CITY OF ALBUQUERQUE

OFFICIAL NOTIFICATION OF DECISION

Project# 1005354
16EPC-40059 Amend Site Development Plan for
Building Permit
16EPC-40060 Amend Site Development Plan for
Subdivision

The above actions for Tract 2-D-1, Arbolera de Vida Unit 2B, and Lot 2, Correction Plat of Sawmill Village, zoned SU-2/SU-1 for PRD and Microbrewery; Lots 3 through 10, Correction Plat of Sawmill Village; Lots 1-A, 1-B and 1-C Sawmill Village, zoned SU-2/SU-1 for PRD; located on Bellamah Ave. NW, between 18th St. NW and 19th St. NW, containing approximately 10 acres. (H-13 and J-13)
Staff Planner: Catalina Lehner

V.3
 SDP 1.0
 SHEET OF

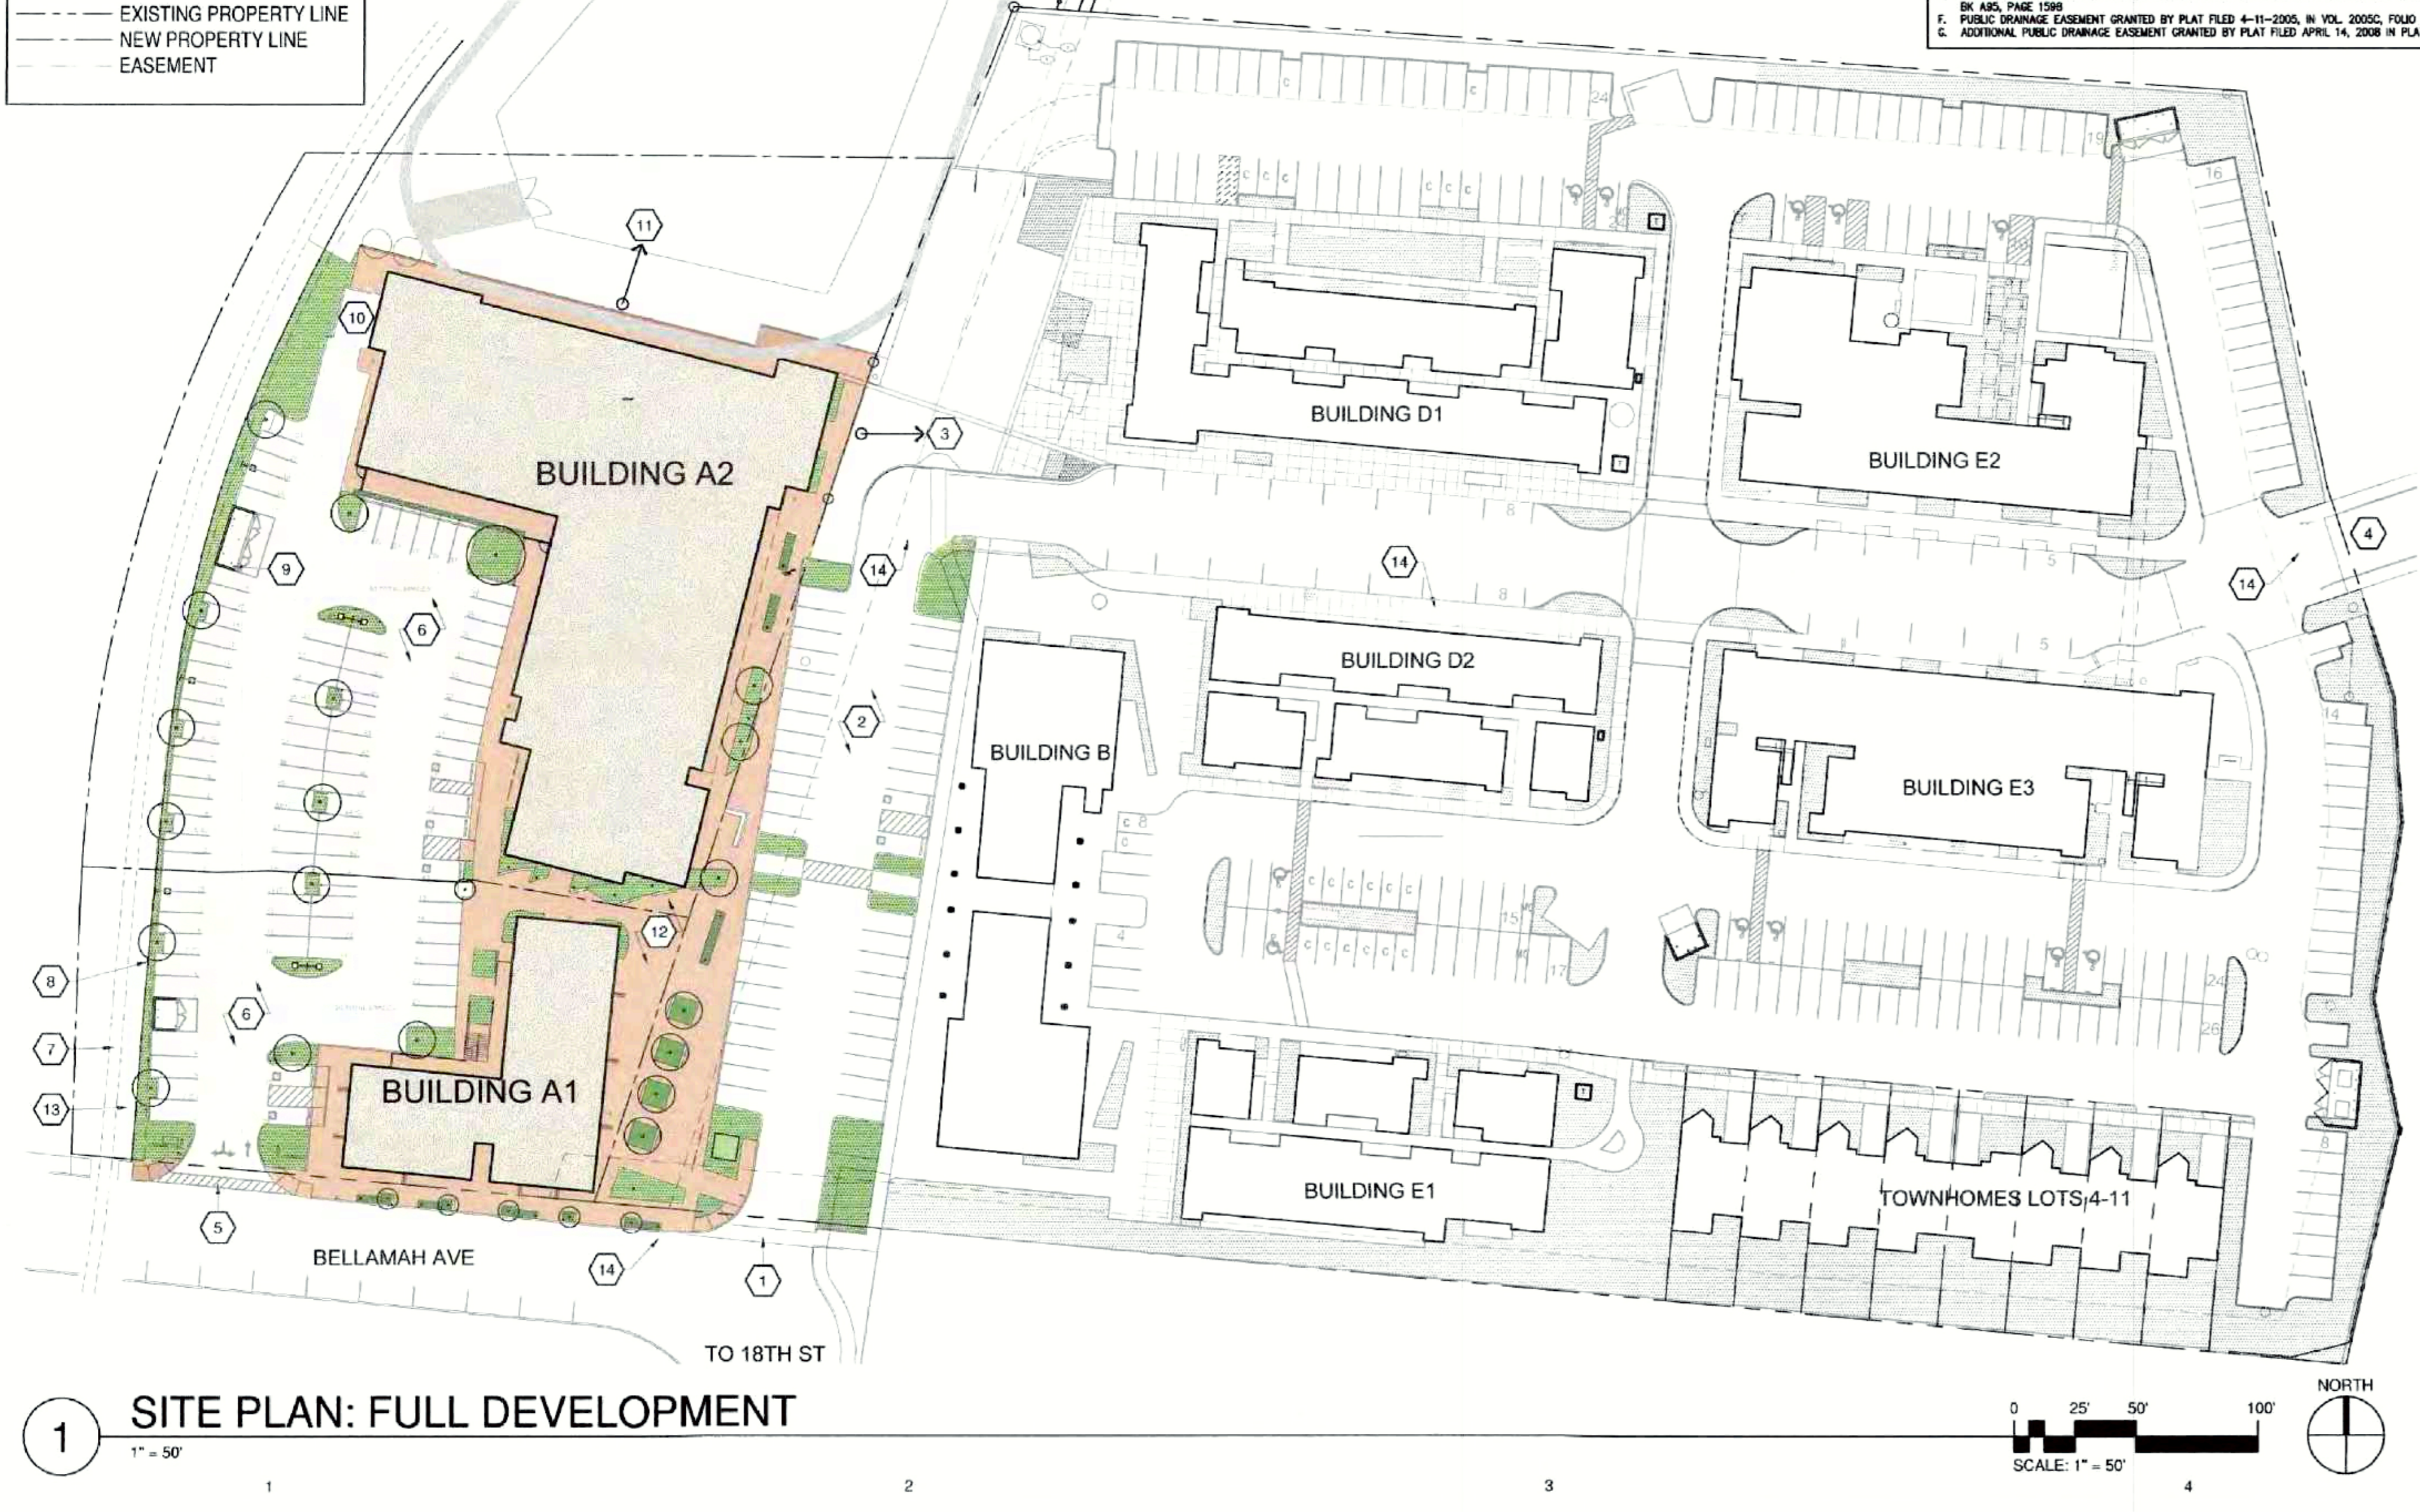
- B. Parking space totals shall be indicated by summary numbers (Sheet SDP 1.1).
 - C. The location of the motorcycle spaces shall be shown (Sheet SDP 1.0).

- C. The buildings shall be dimensioned and their square footage totals listed (Sheet SDP 1.0).
10. Pedestrian Access & Circulation:
- A. Clarify if the path that runs south-north along the subject site's eastern side will provide both on and off-site connectivity to recreation and facilities (Trails & Sidewalks section- Design Standards).

N Landscape Plan
Sawmill Village

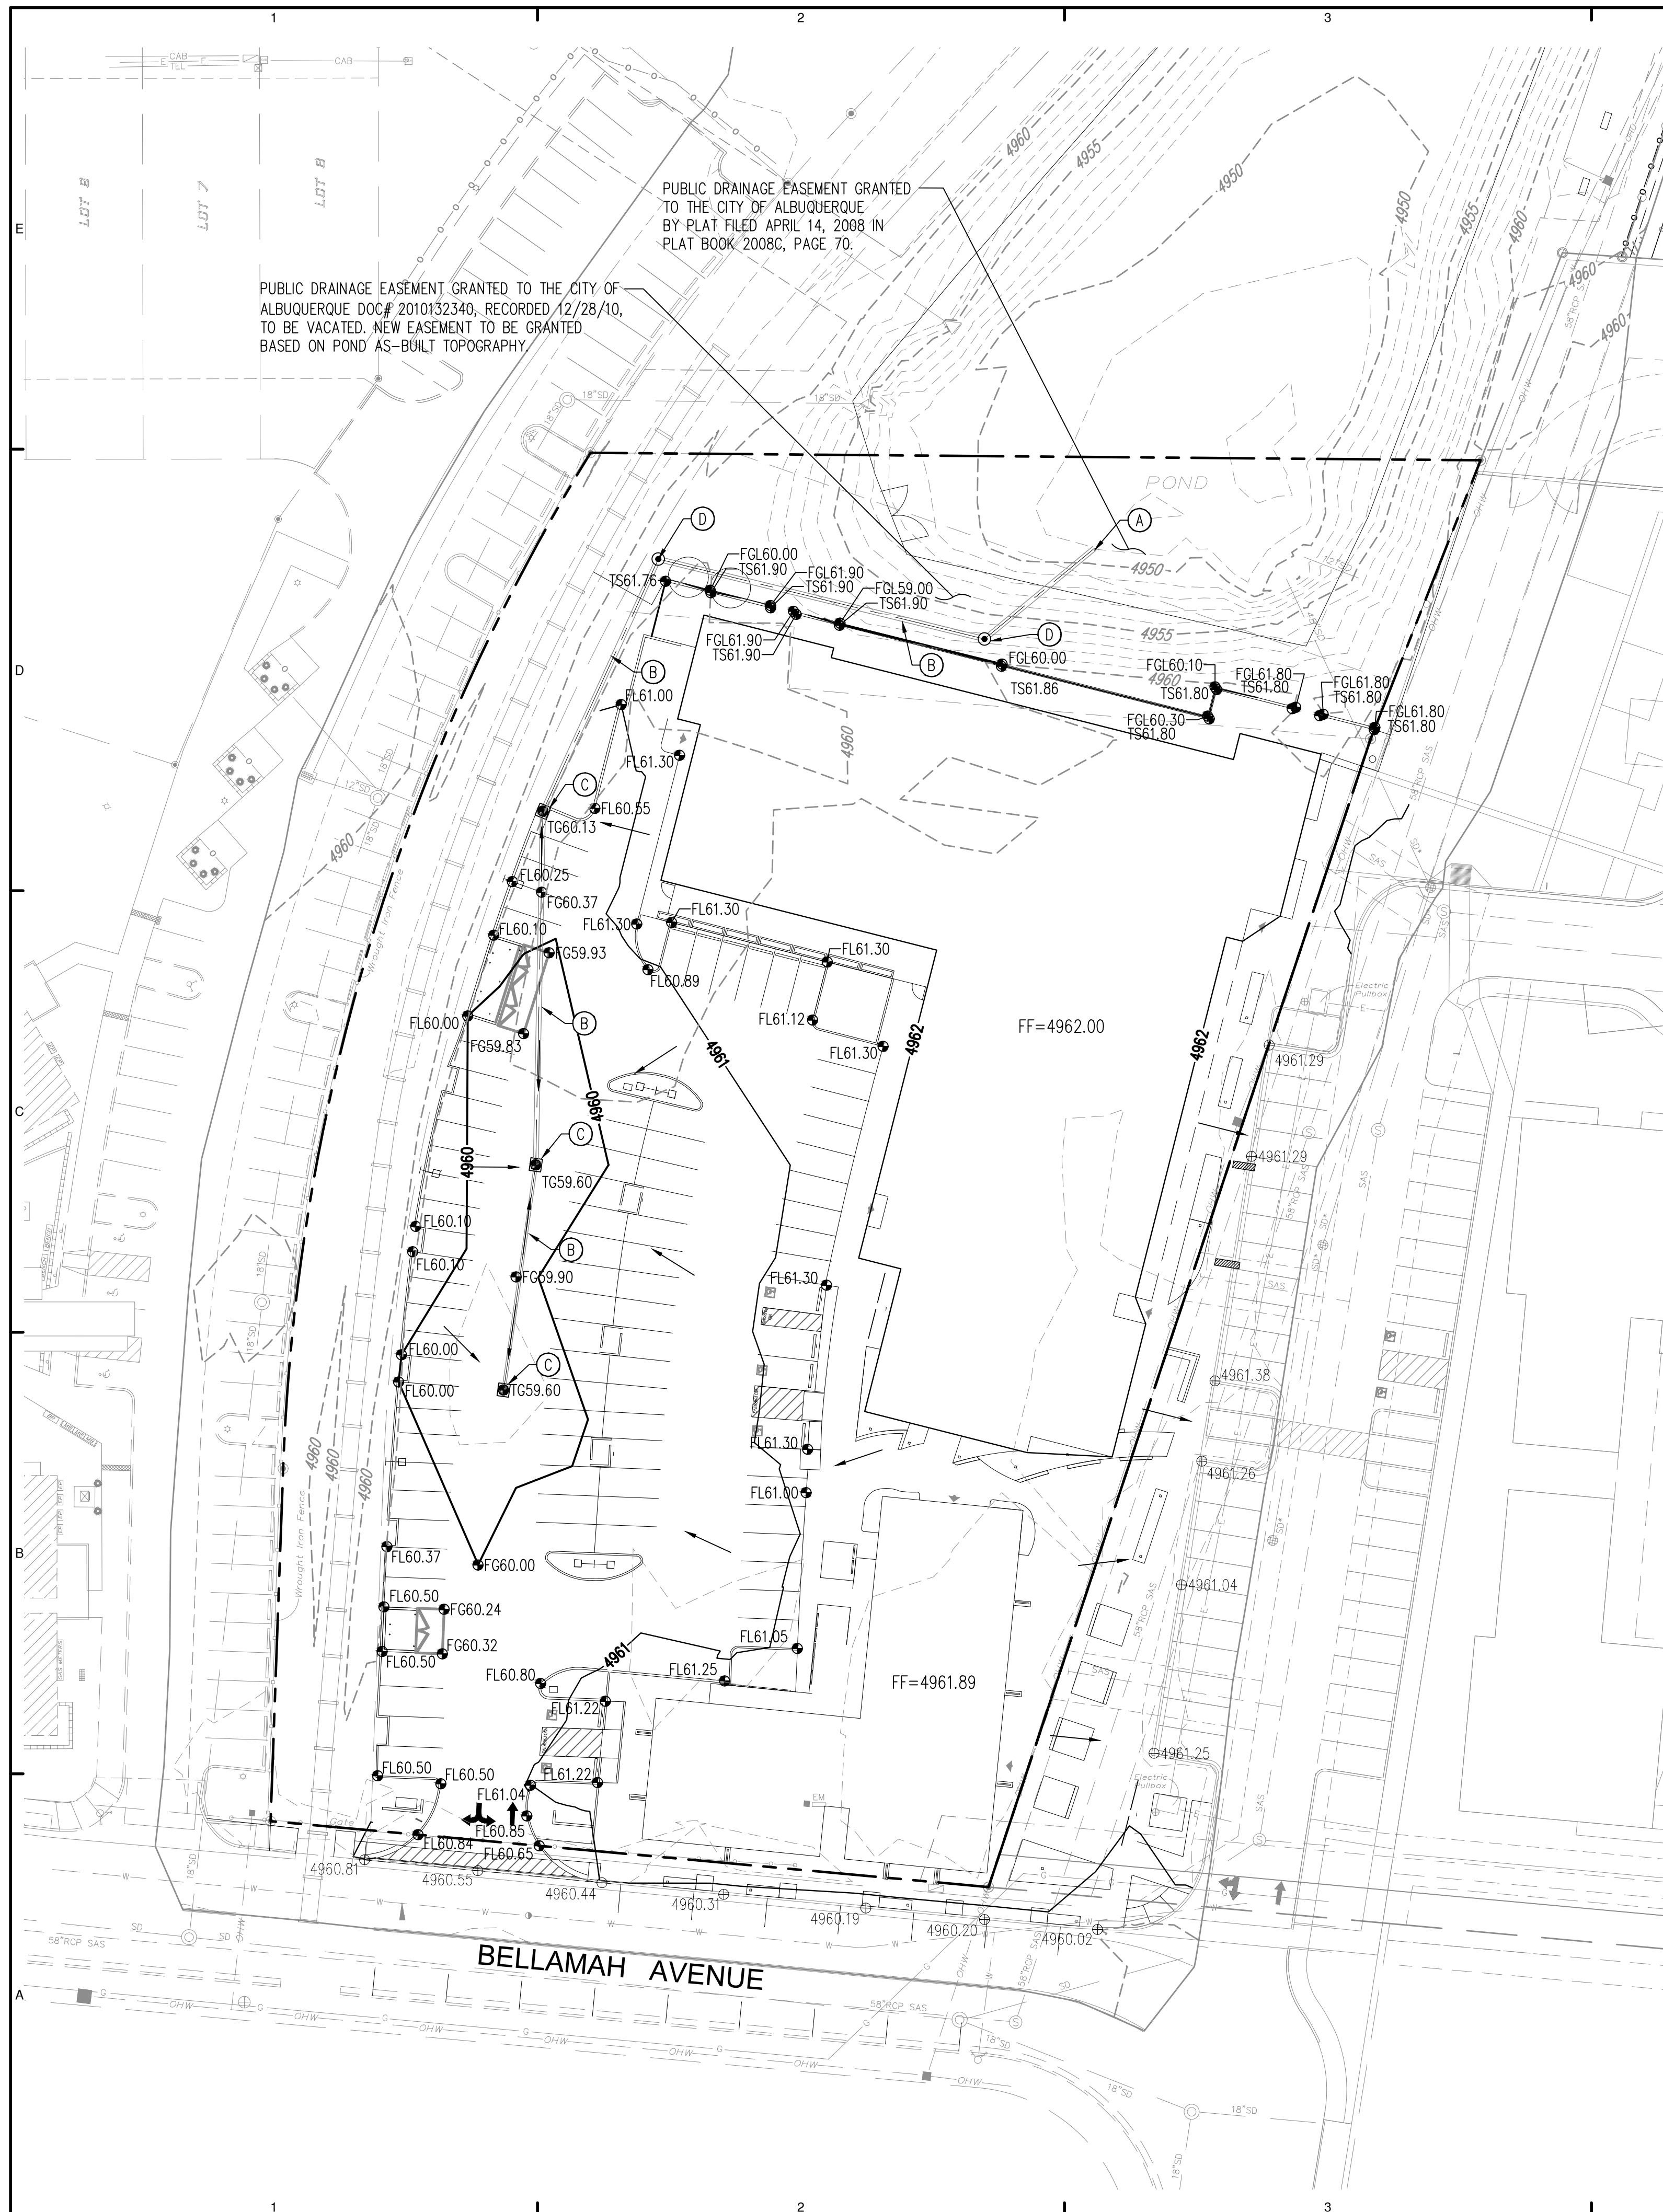
6. Landscaping:
 - A. One of the two additional trees (the northernmost one) approved with the 2011 landscaping plan, along the western boundary of Phase II, shall be included with the current landscaping plan.

- B. The trees along Bellamah Ave. shall be of a tall, canopy-forming variety (such as the Red Oak approved in 2011 or a canopy-forming tree on the current landscape plan legend).

EXTERIOR
ELEVATIONS

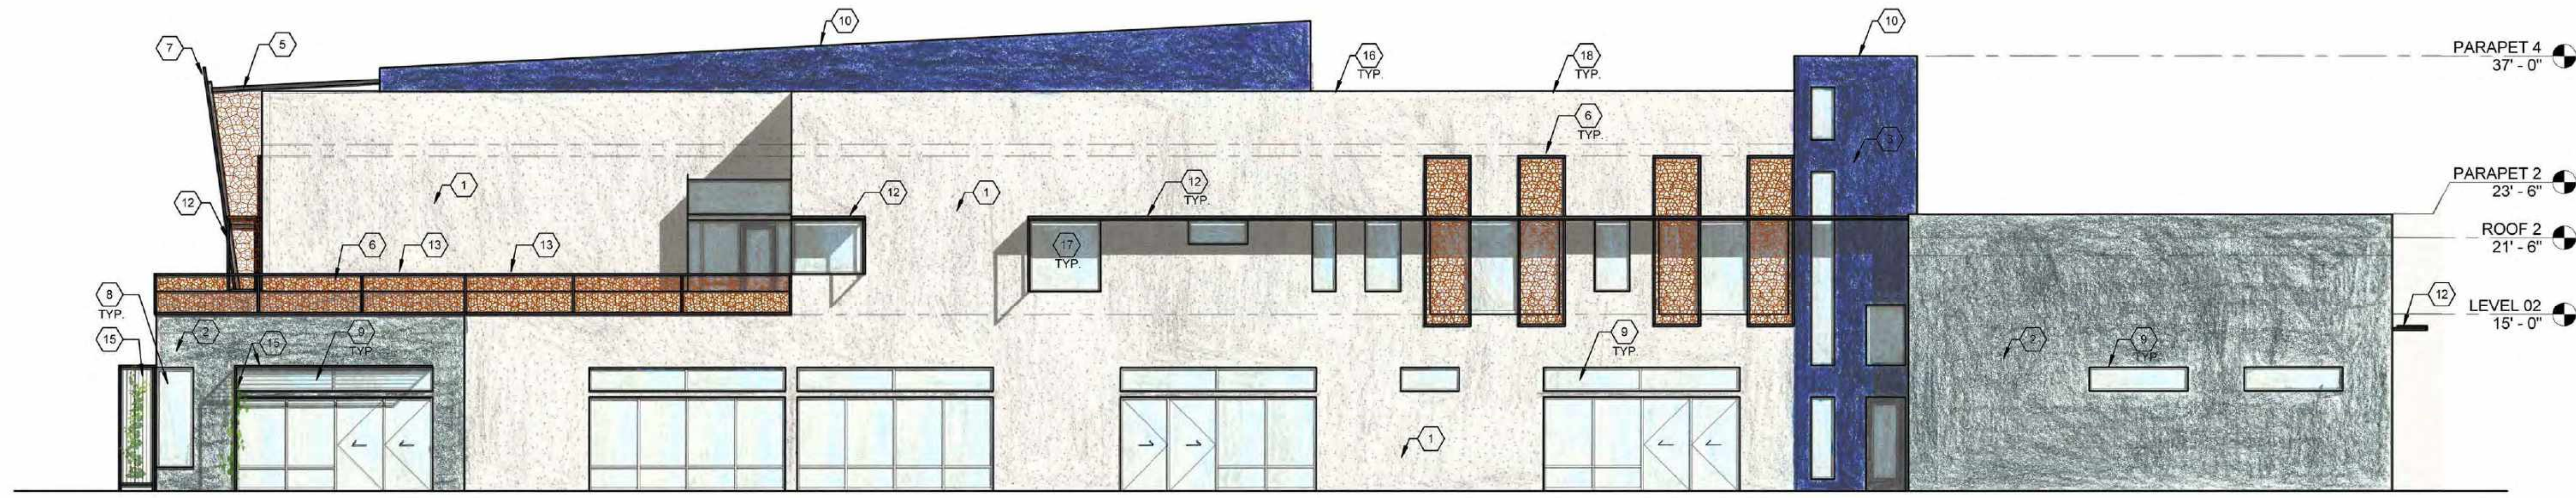
4. SWPSDP General SU-2 Regulations:
 - A. A note shall be added to the elevations to indicate that mechanical and electrical equipment shall be screened from public view (Regulation 4.d).

- B. A note shall be added to the elevations to indicate that reflective glass is prohibited (Regulation 4.f).
5. Parking:
 - A. The parking space counts for the approximately 10-acre site shall be verified and the Parking Table(s) shall be updated correspondingly.

- B. A note needs to be added to the elevations to indicate that roofs will be a low heat absorbing, single-ply material in a light color (Roof Materials & Colors section).
